Rezoning Transportation Analysis

Petition Number: 2022-187

Revision Log:

Date	Description
3-22-23	First Review (IW)

**RZ-1.0**

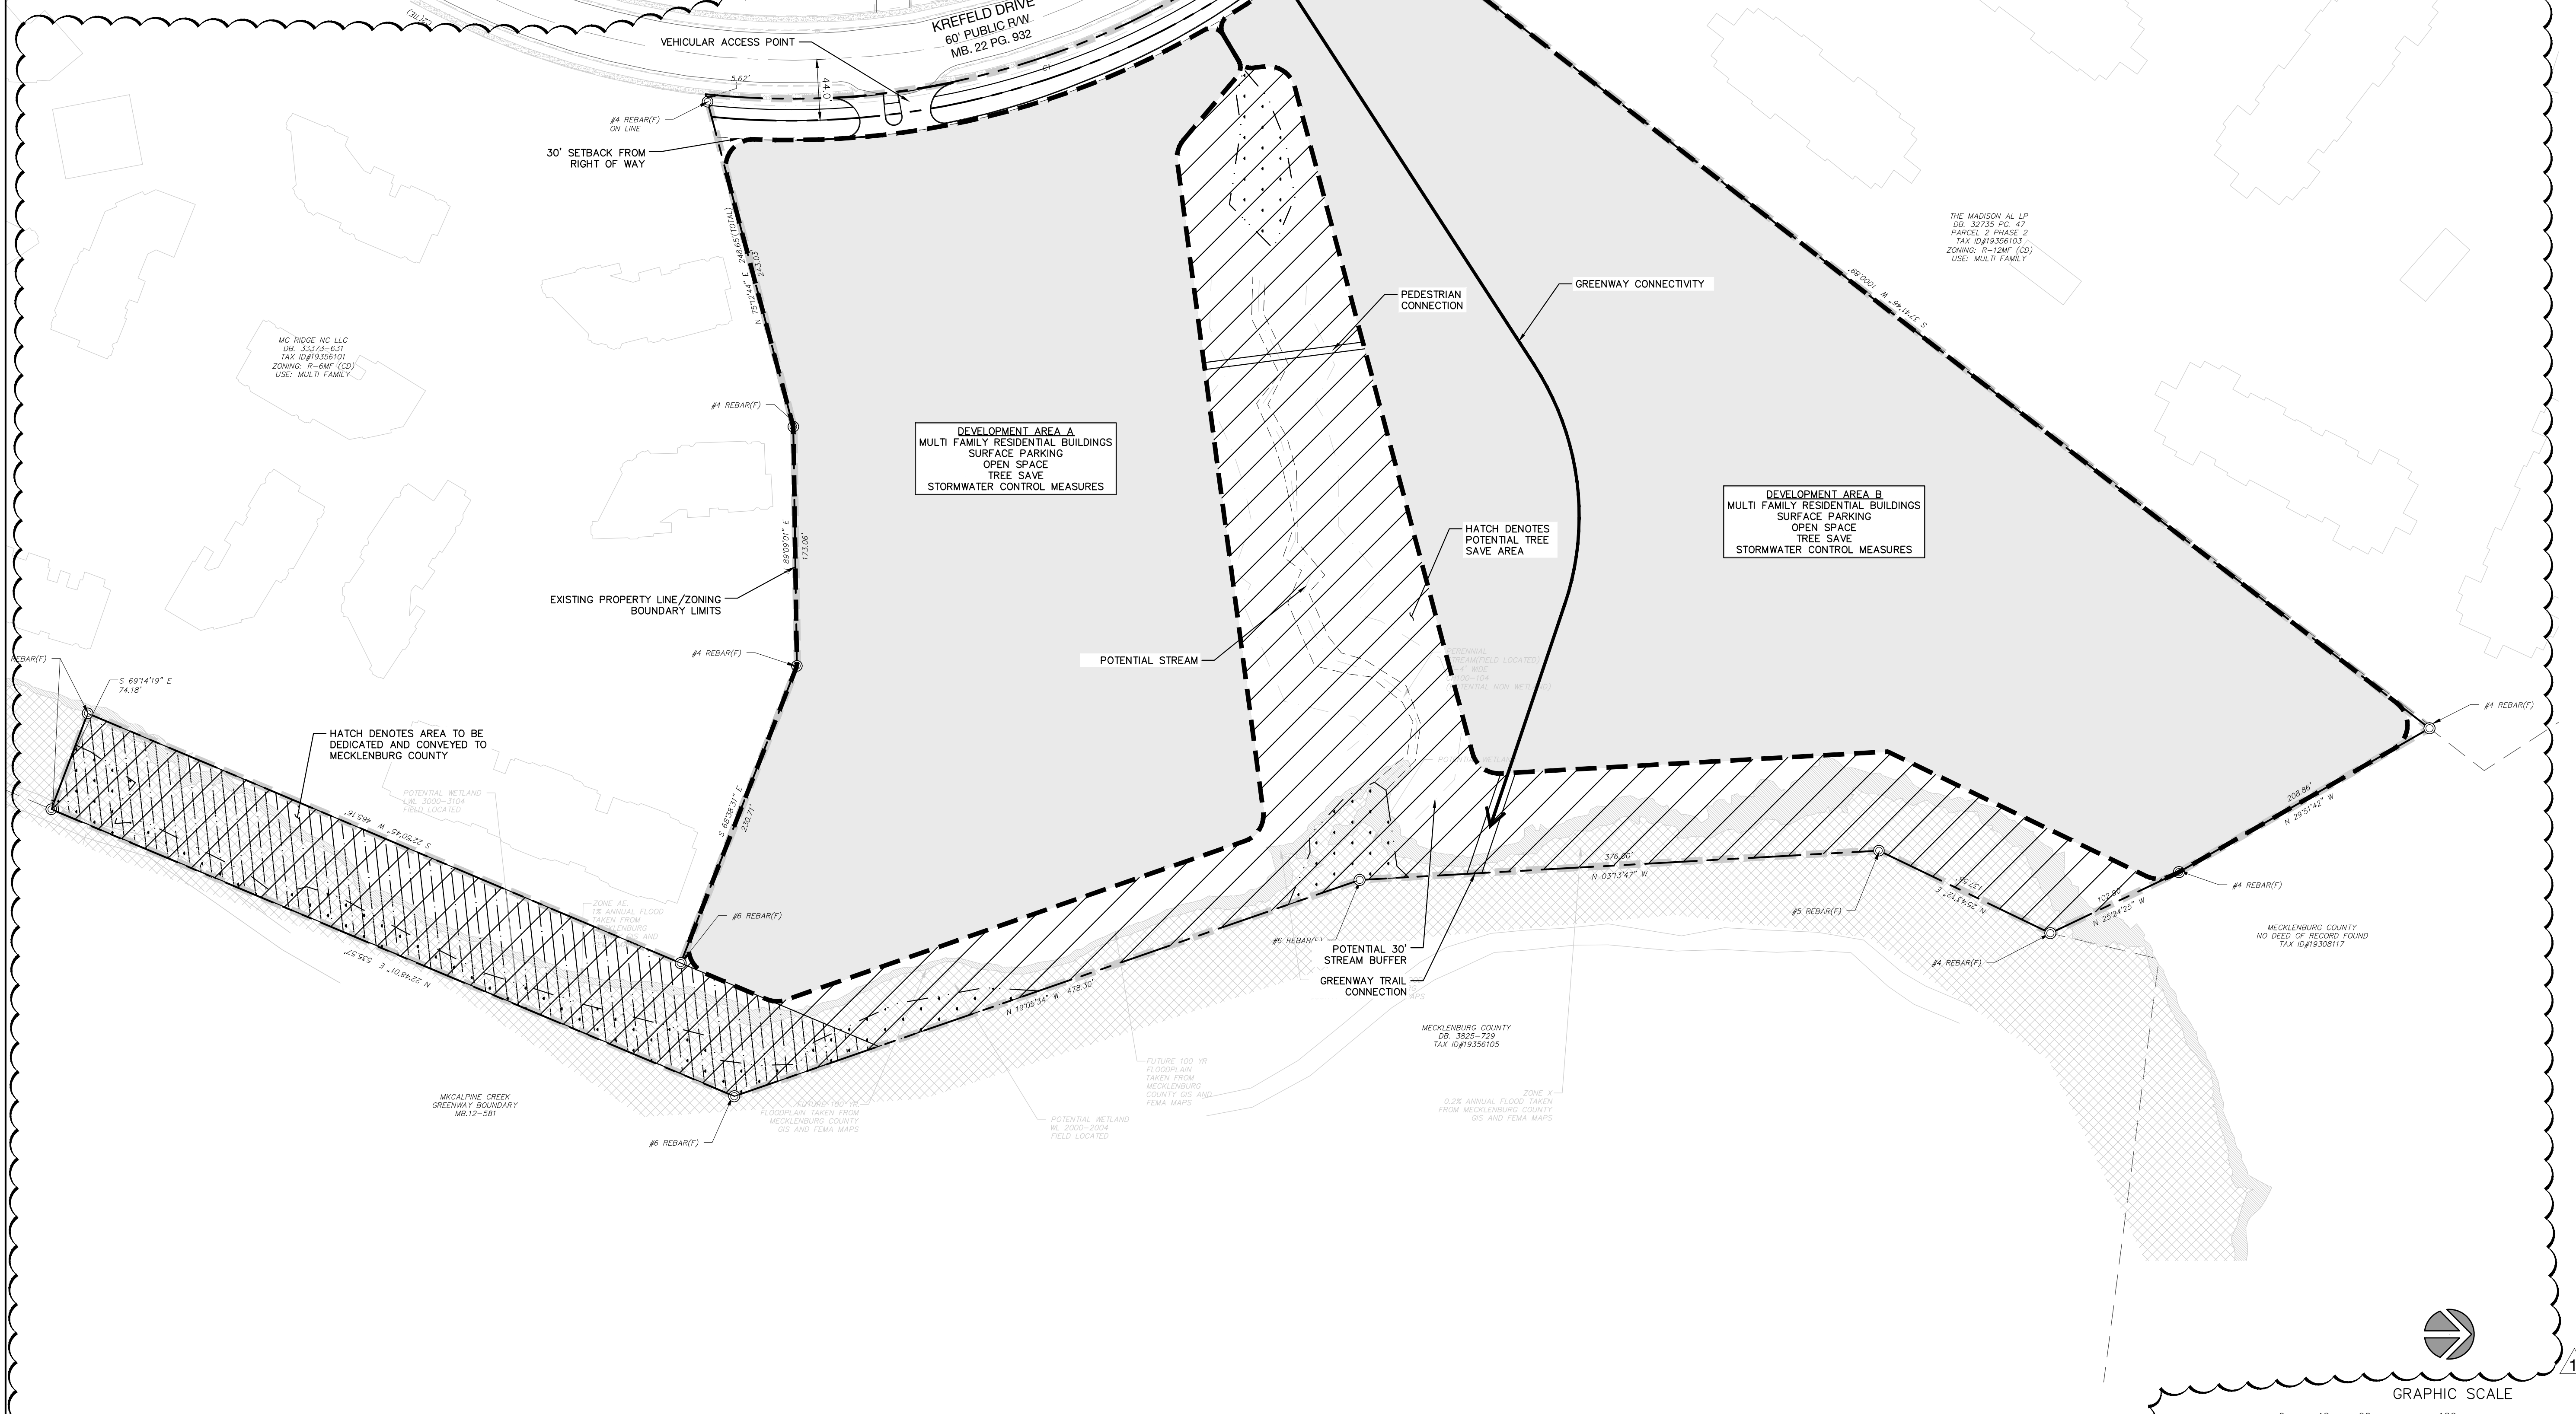
- a. **Krefeld Drive:** CDOT requests the location of curb and gutter to be moved to 24 feet from roadway centerline to accommodate the Charlotte Streets Map with a roadway typical section of 2+ Avenue with bike lanes.

Label and dimension the curb and gutter from the centerline for each road on the site plan.

- 3. Revise site plan and conditional note(s) to commit to dedicate 40' of right-of-way from the road centerline. The site plan shall label and dimension the right-of-way from the road centerline.

Revise site plan and conditional note(s) to commit to construct bicycle facilities by locating the curb and gutter 24' from the center line to meet the Council-adopted Charlotte BIKES Policy and to support Council-adopted Charlotte Streets map.

- 5. CDOT Request: Revise site plan and conditional note(s) to commit to creating a full public access greenway connection from Krefeld Drive to connection shown on site plan and extending to existing greenway behind property if developer is given real-estate or permission to construct by Mecklenburg County.
